From:
Sent: 17 February 2026 12:48
To: louise.bearcroft@kirklees.co.uk; DC Admin
Subject: Objection to Planning Application 2025/92737 and 2025/92713

Ms Bearcroft
Subject Planning Applications:
2025/61/92713/E

Comments / Concerns re the Latest Revised Plans

Client	PPJ Developments	Issued From	
Project	2539 - Moor Lane - Residential	Date	August 2025
Title	Proposed Site Plan	Scale	1:250 @ A1
Drawn	BH	Auth	BH
Revision

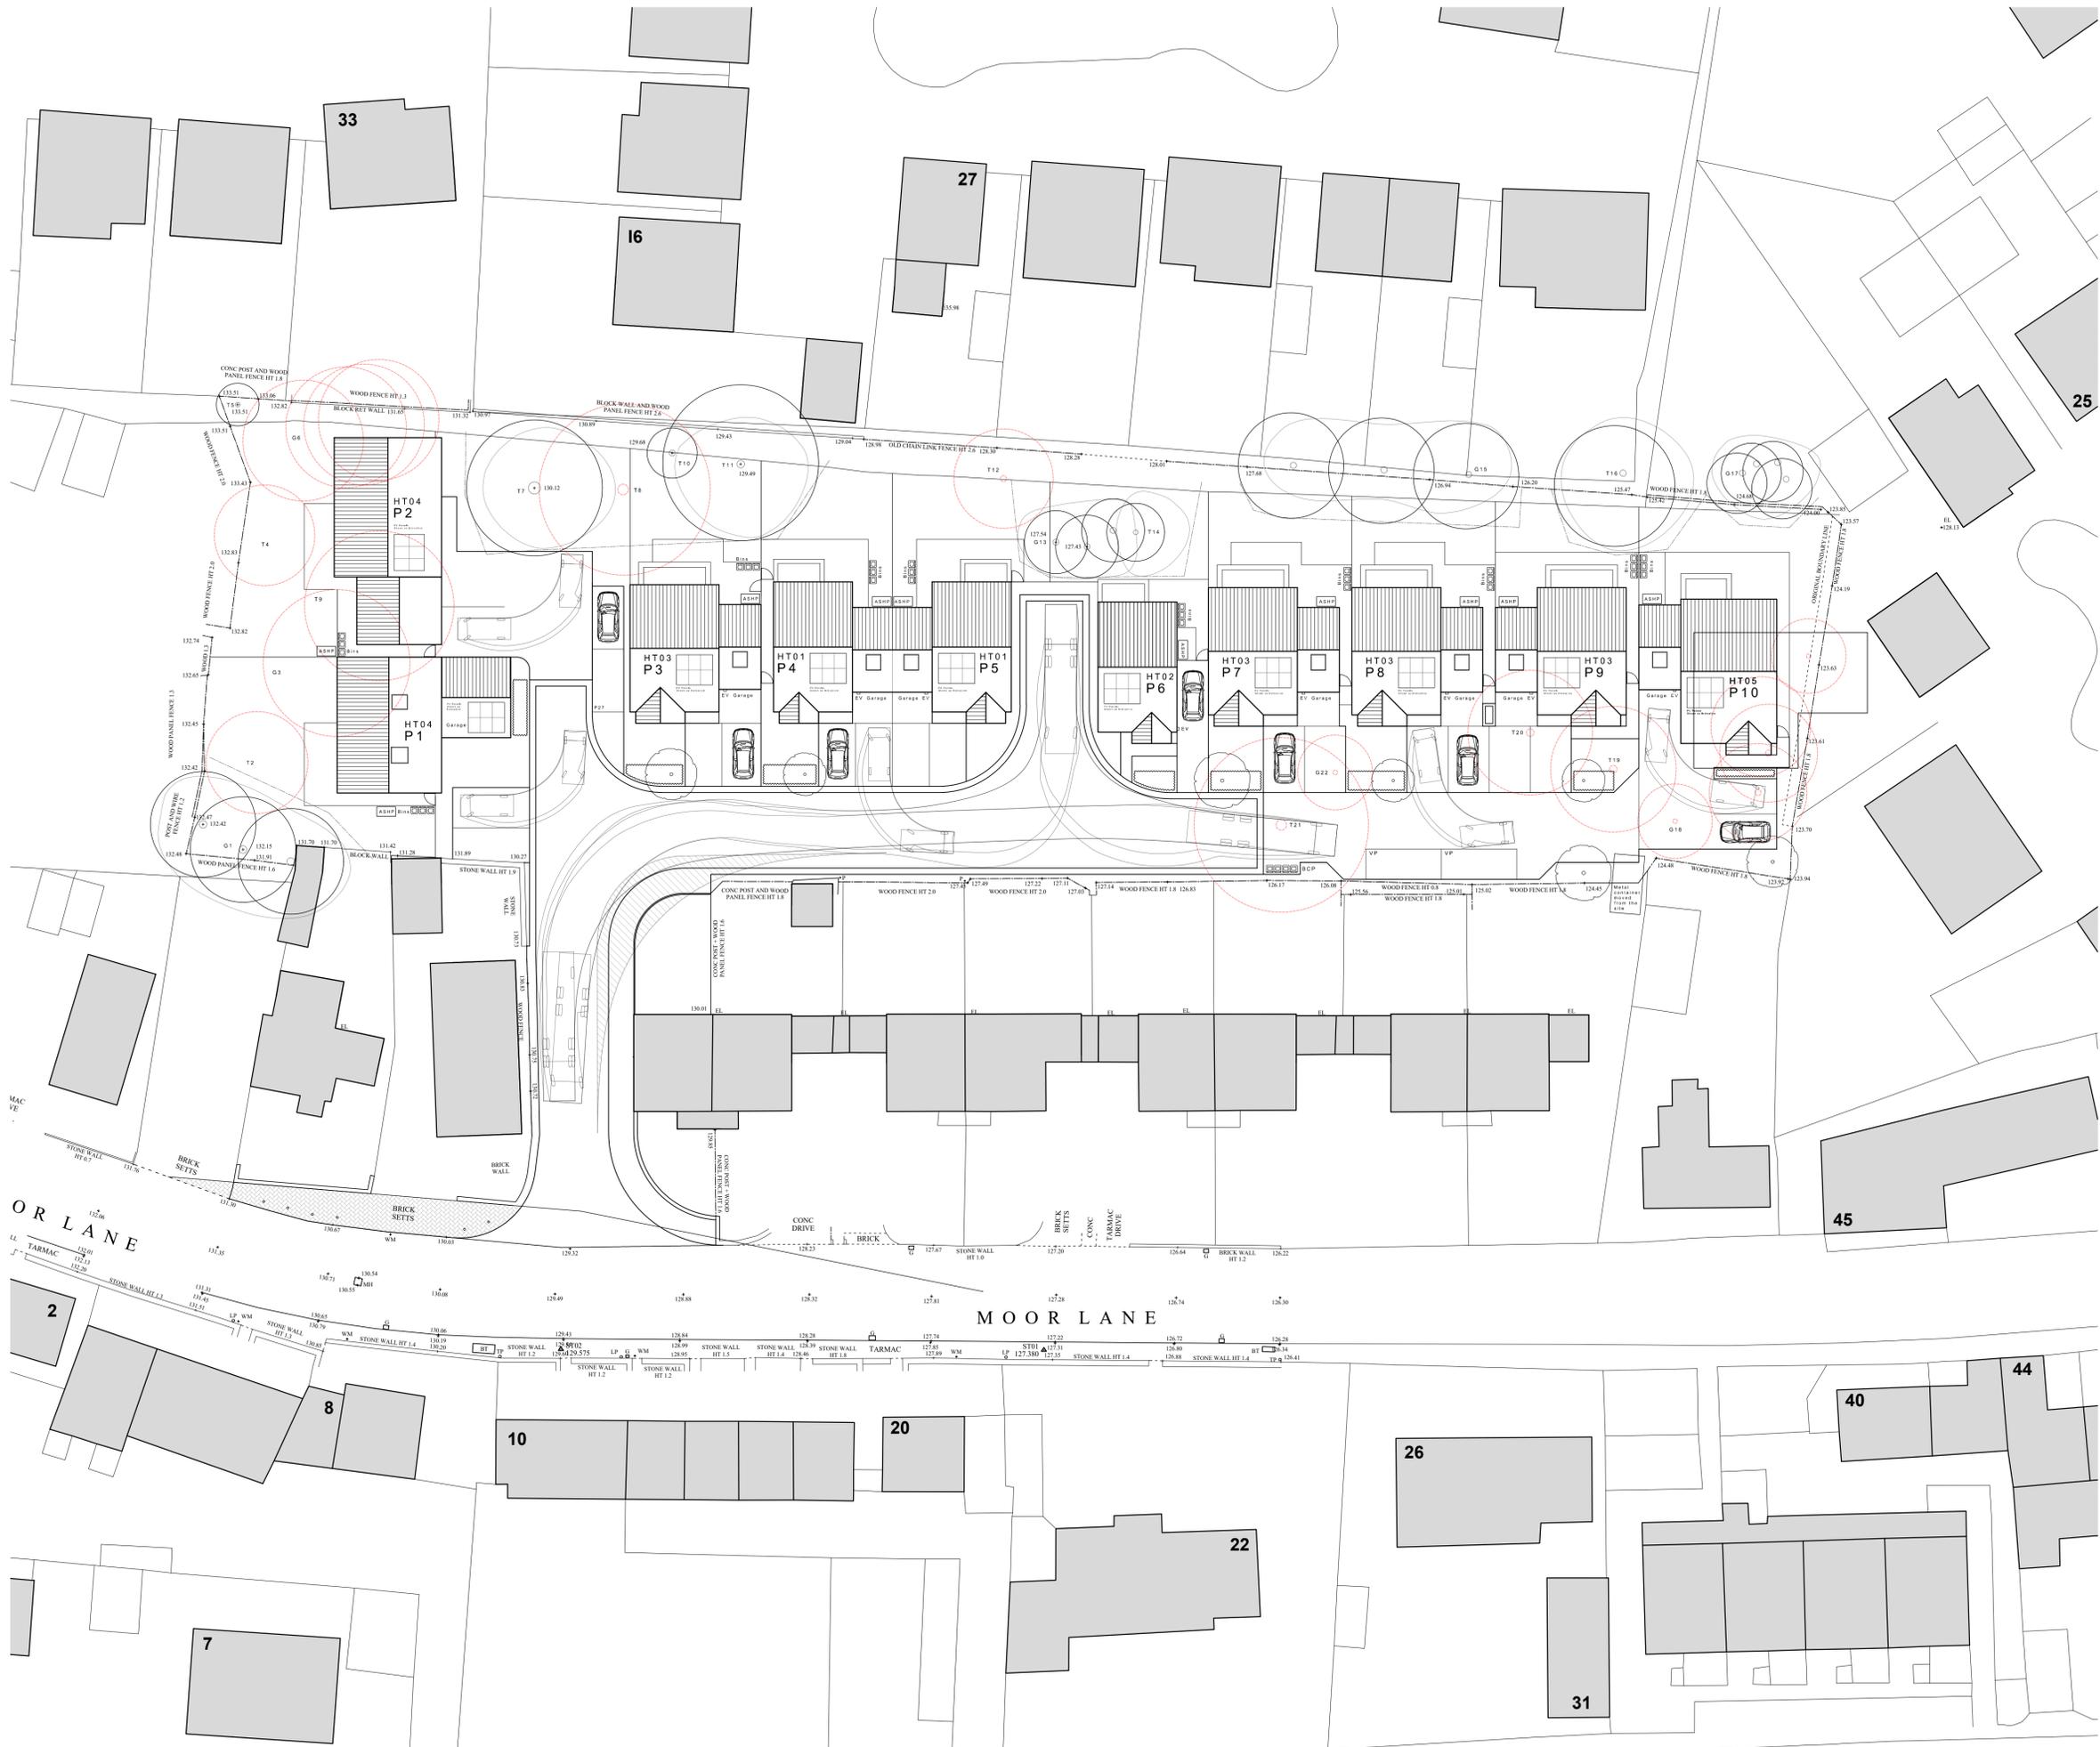
Originally 6 No 3 Bed and 4 No 4 Bed houses were planned for, and approved.
The latest plans show 6 No 3 Bed, 2 No 4 Bed and 2 No 5 Bed Houses along with attached Garages to 9 of these properties.
Also additional Bedrooms or Office accommodation is being provided above these garages.
Plot 1 is also shown as a 3 storey house rather than the 2 storey house indicated on the approved plans.
Also the distance between each of the properties appears to be between 900mm and 1.00 metre and bears no relationship to the outline application.
Bearing in mind the Councils earlier decision on the 23rd June 2023 to refuse permission on the basis of the development proposal **being cramped and invasive**, this issue has not been addressed.

Plot 3 Bin store route appears to be down the foot path belonging to Plot 4.

The 2 parking spaces for 27 Moor Lane will have to be accessed off the private block driveway of Plot 2 and seems illogical.

Also 2 visitor car parking spaces are in an equally ridiculous position, and again these are off the private block drive serving plots 7, 8, 9 and 10, which will no doubt be used by the house occupants.

There are still no “Communal Enhanced Habit Zones “ indicated on the latest plans. Originally 3 separate areas were proposed, one adjacent Plot 1, a second adjacent Plots 2 and 3, and a third adjacent Plots 5 and 6 totalling 465m²

Plot 10 is shown as being 8.876 metres away from No 21 Summerdale measured at an angle towards their property. However, they have not shown the conservatory that is only a metre or so away from the boundary.

A measurement of 15.109 metres is shown to No 23 Summerdale which is totally irrelevant and has no bearing on the issue.

The fact of the matter is that the North East gable of Plot 10 will be only metres away from the boundary and will also be approximately 2.00 metres higher than the Ridge of 21 Summerdale.

Access Road Eastern Elevation (towards 25 Moor Lane) as proposed 1: 100

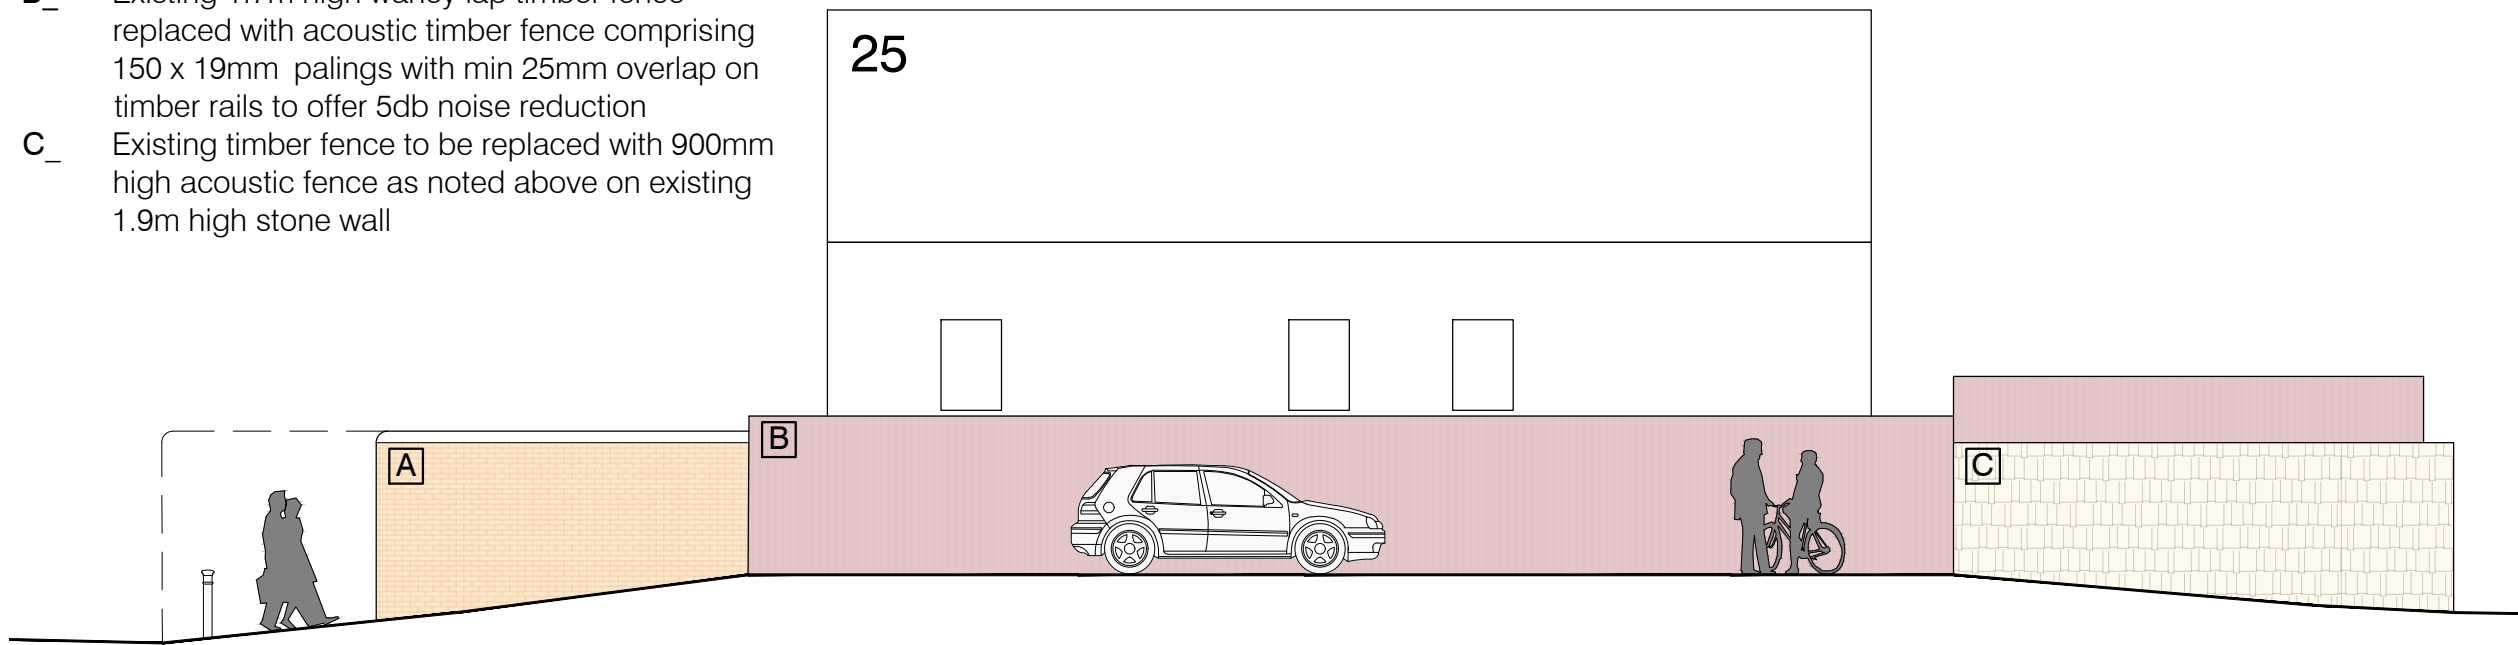
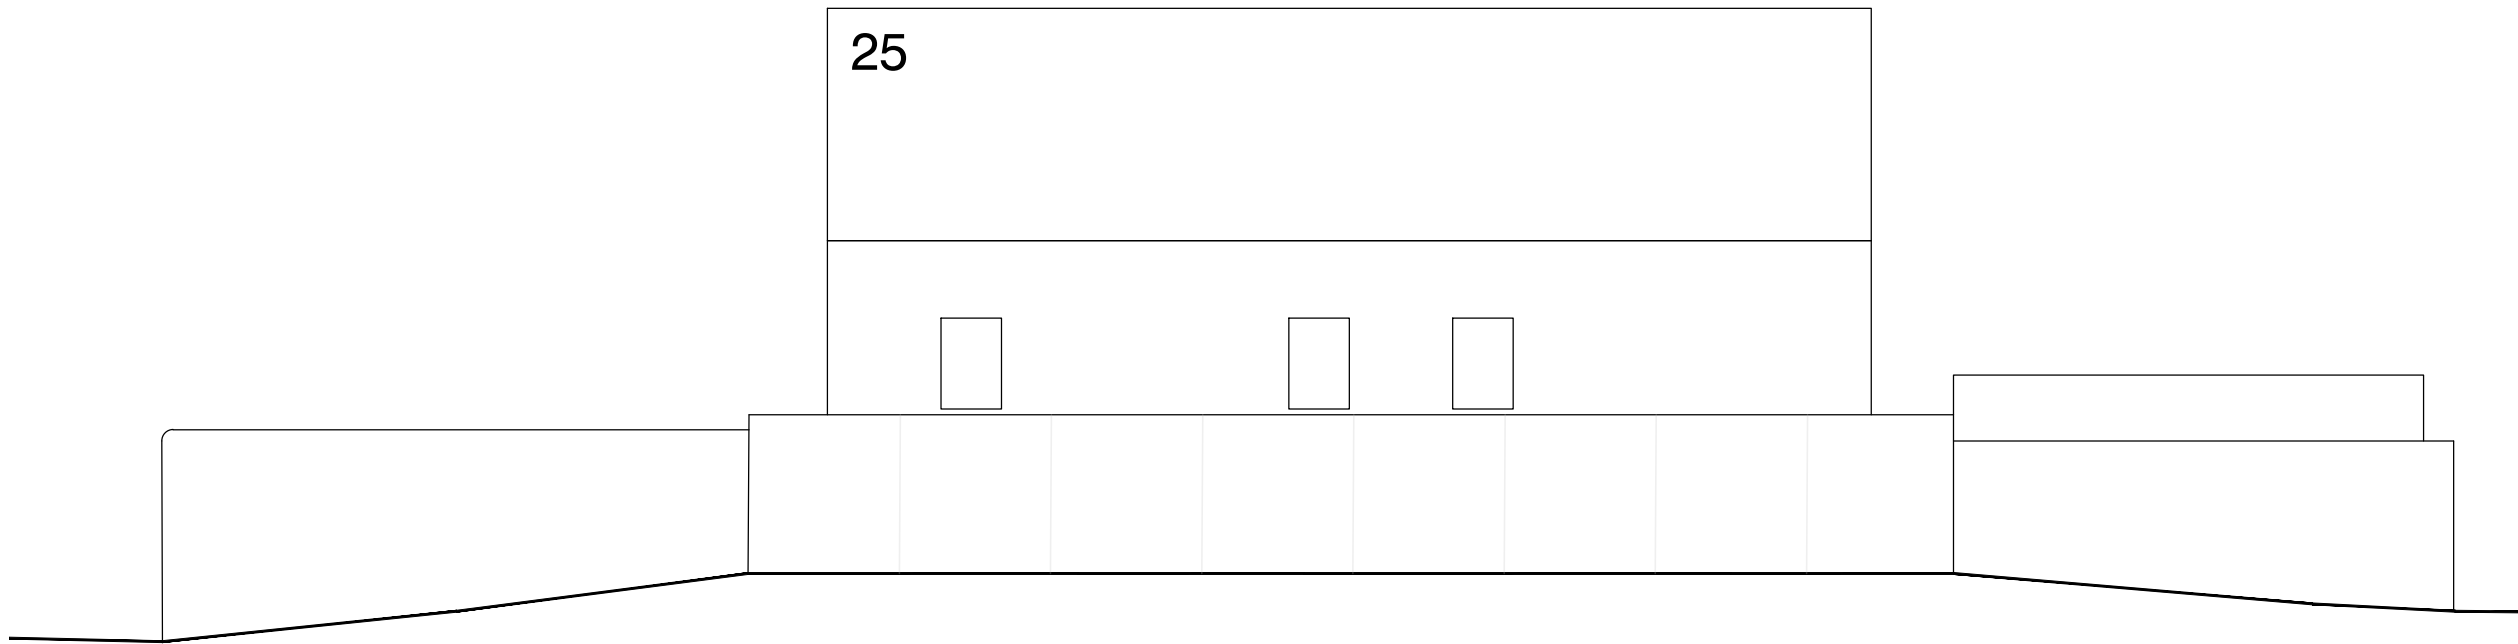
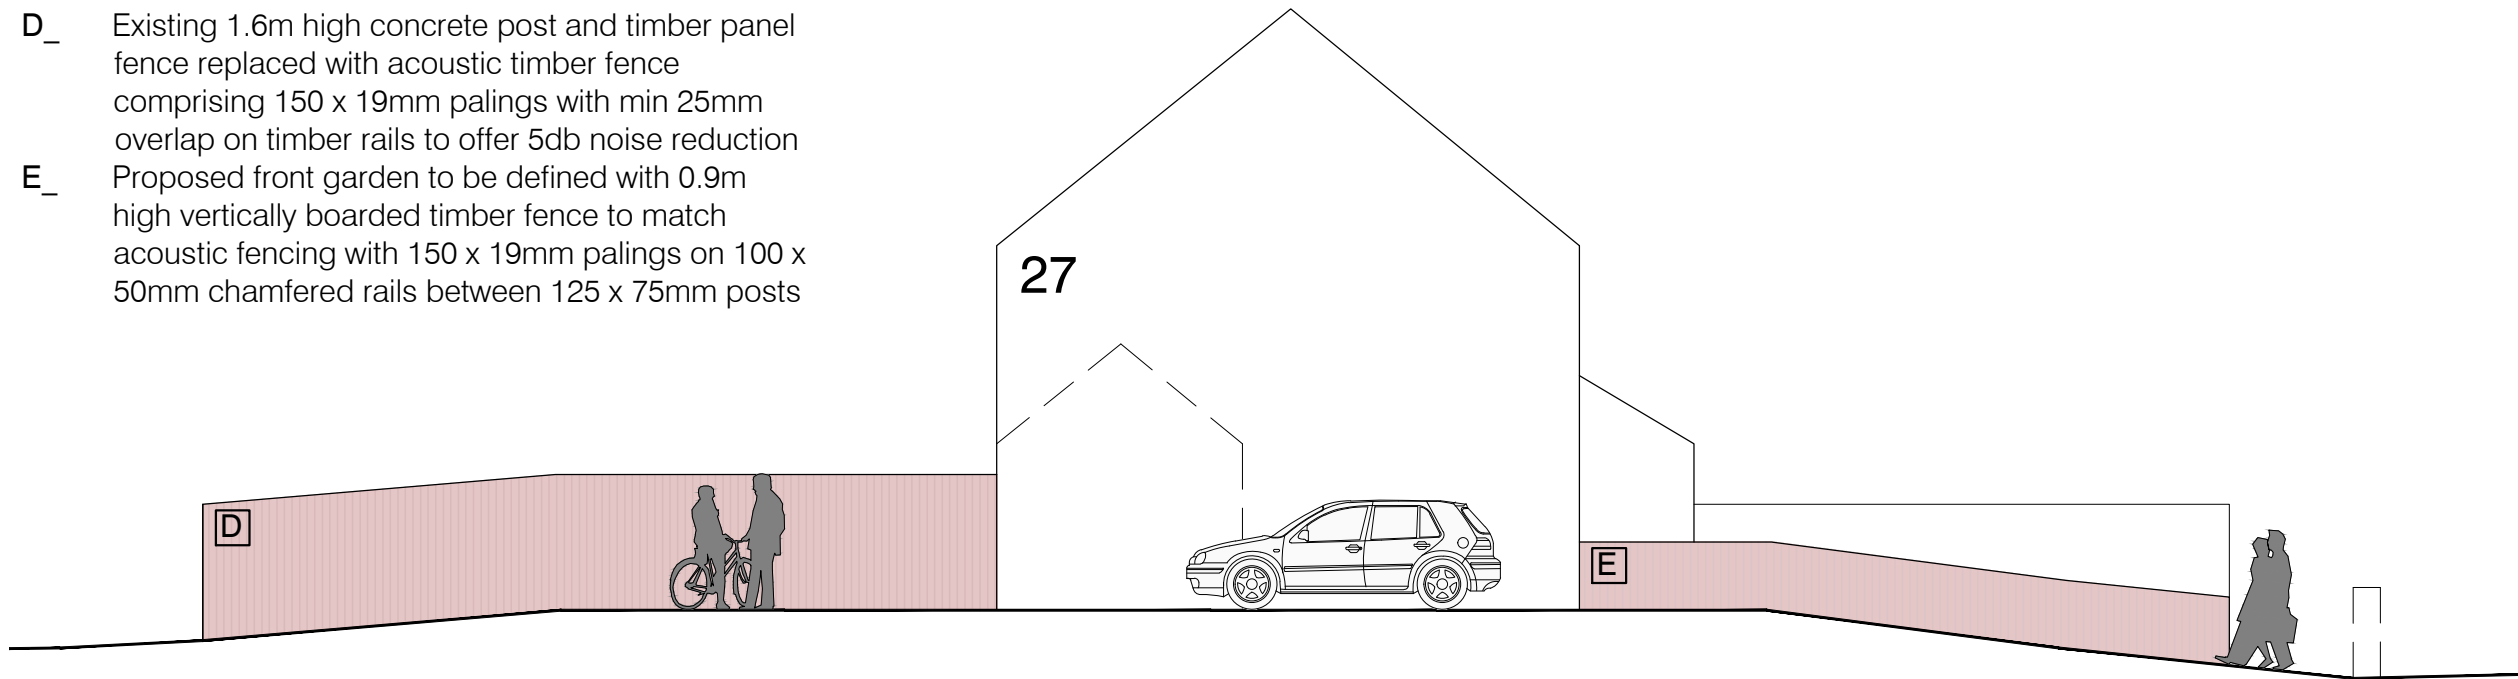
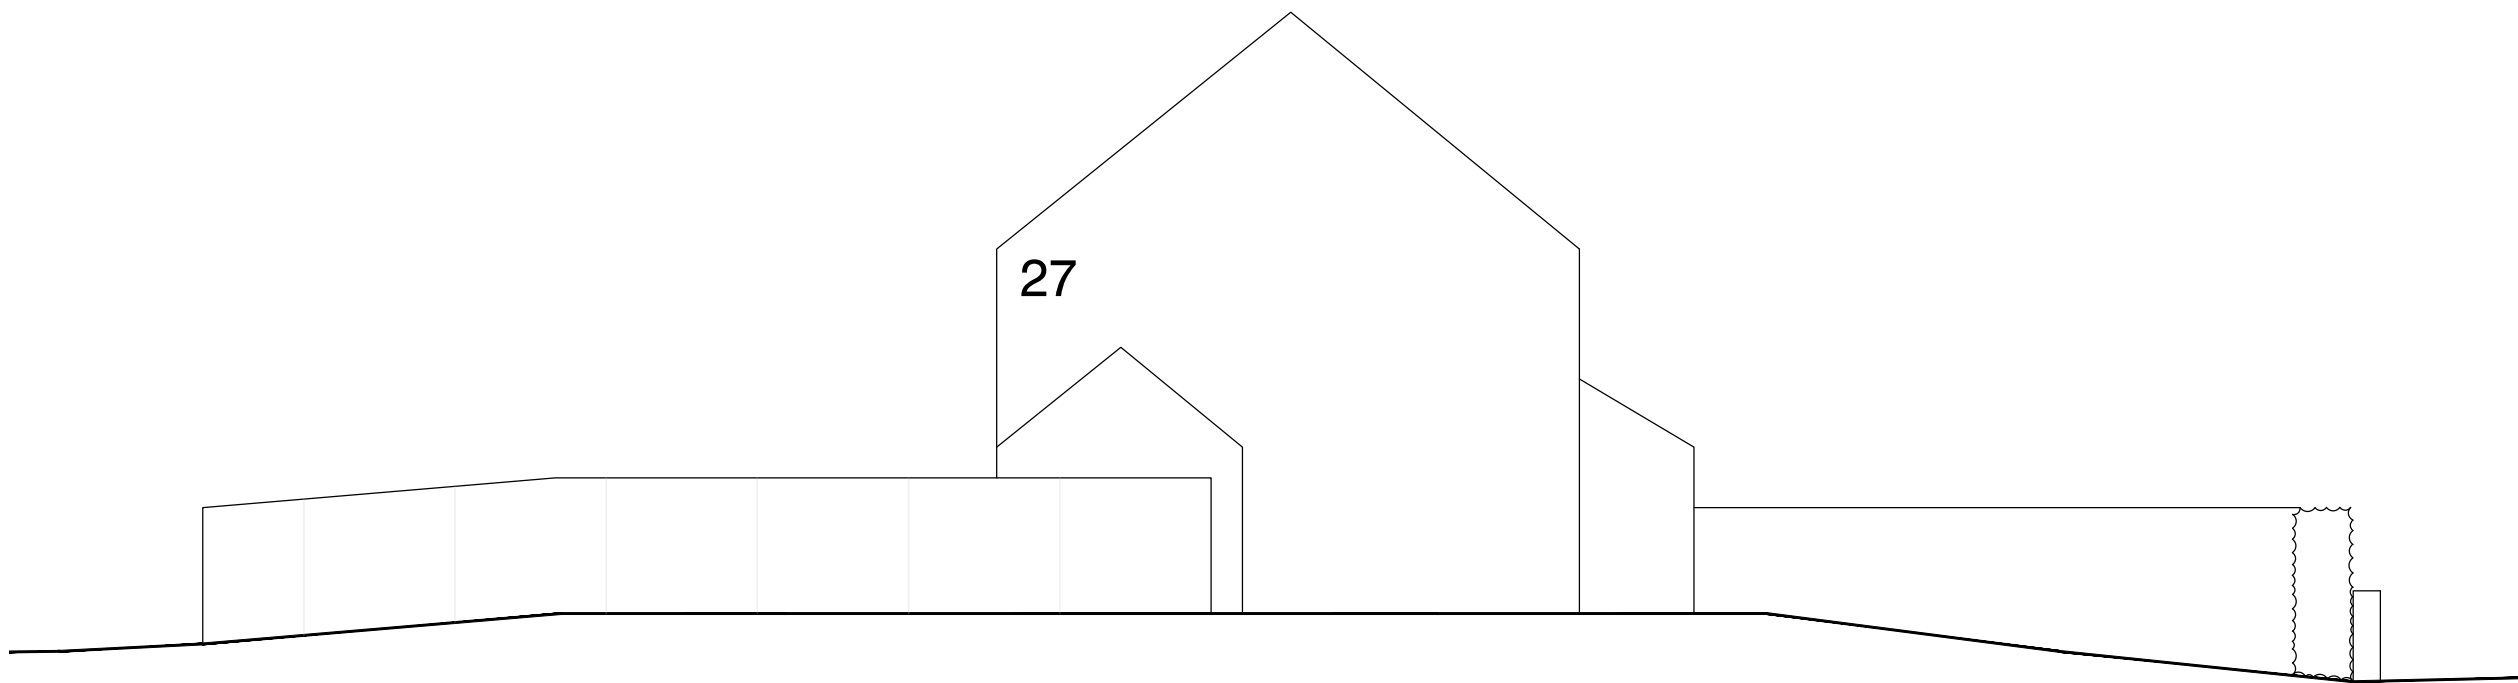
I often walk up Moor Lane and regularly see cars having to stop and give way in the vicinity of the access to the site. I can see that despite best attempts the sight lines do not work.

The main problem is that vehicles coming up Moor Lane are not on the left hand side of the road, but straddling the centre line, or worse right over to the right. As such some vehicles cannot be seen until they are 10 to 15 metres from the entrance.

Furthermore the actual kerbs have still to be finished in the vicinity of the boundary of No 29, and it appears to me that the sight line will need to extend over their boundary and garden to fulfil the requirement.
